**Planning Application Ref:** **AW/346/17/T**

**Location:** **1 Shipfield, Aldwick**

**Description of works:** Fell 1No. Cyprus Tree and replant with smaller deciduous tree

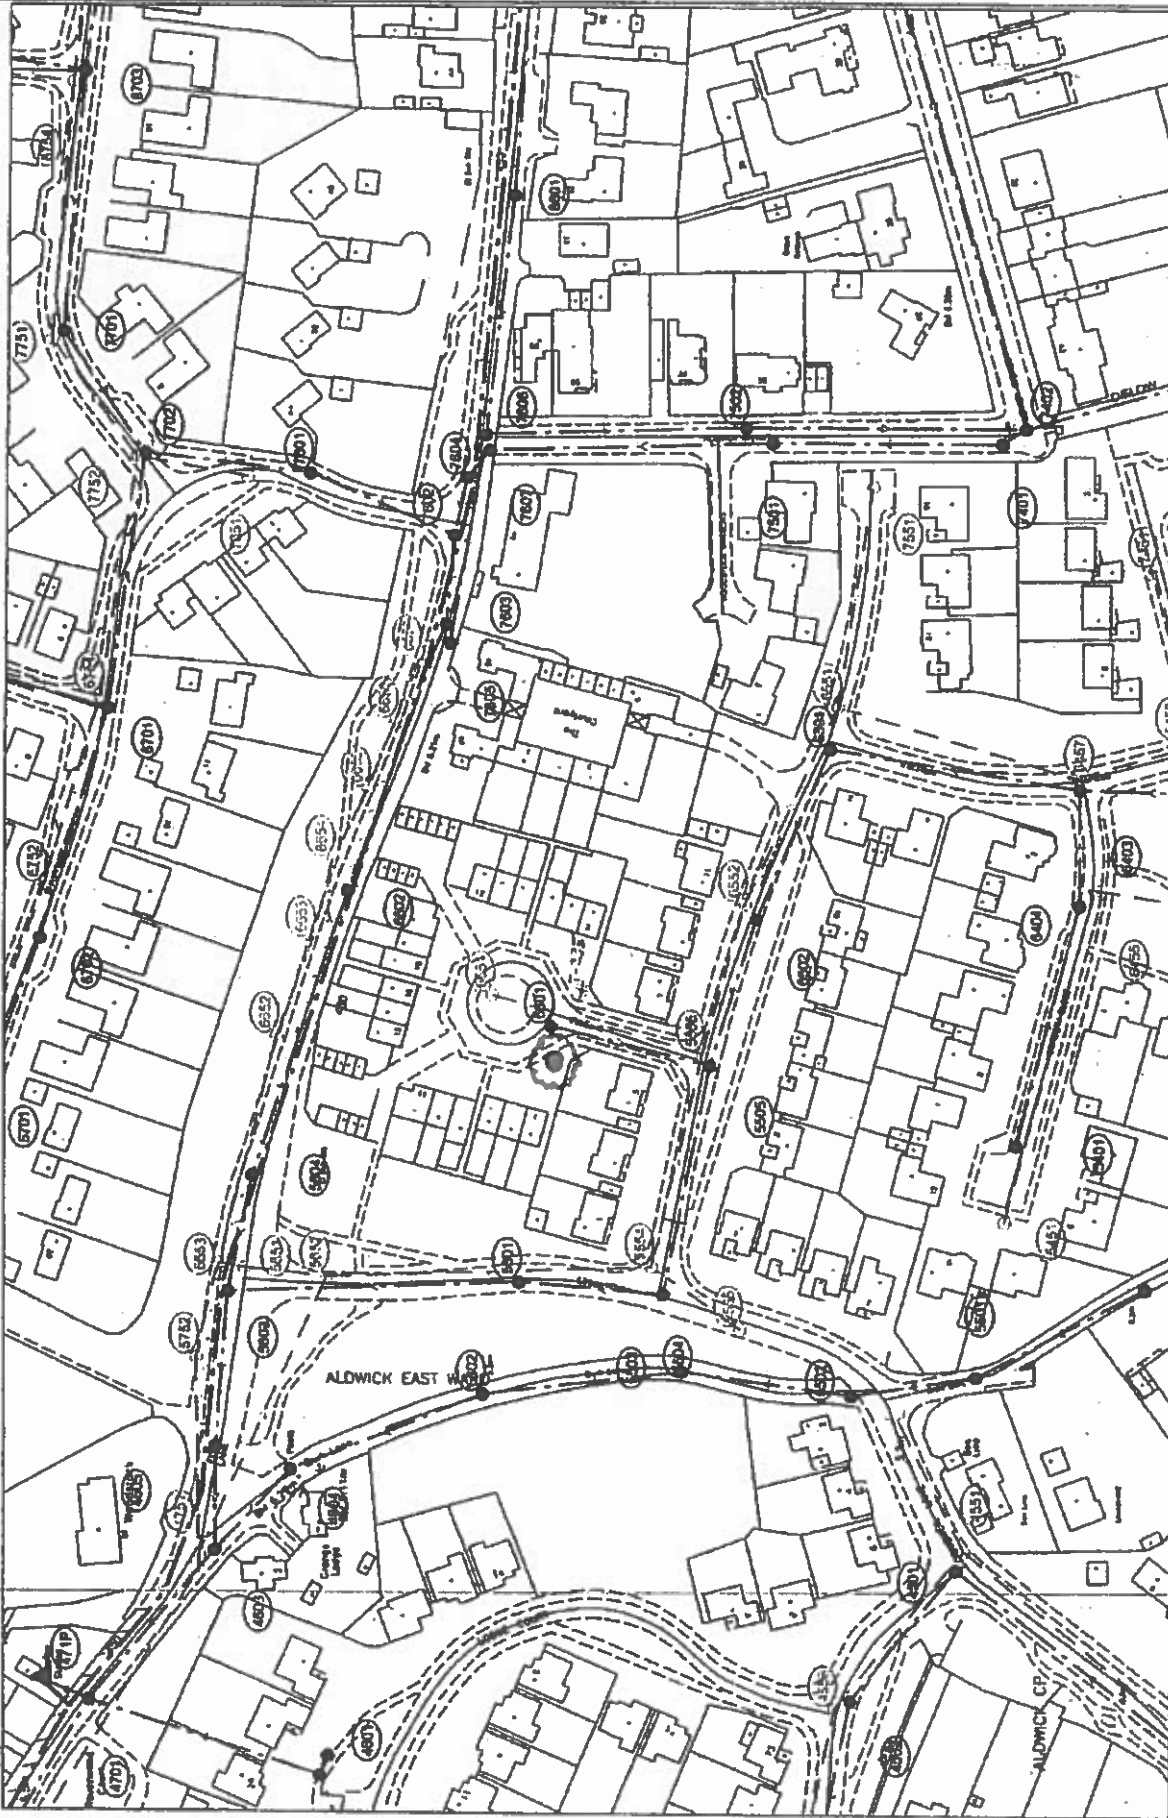
- Although proximity of tree roots to drains can be a concern, no evidence has been submitted that would implicate this tree in a damage event or suggest it has a foreseeable risk of doing so.
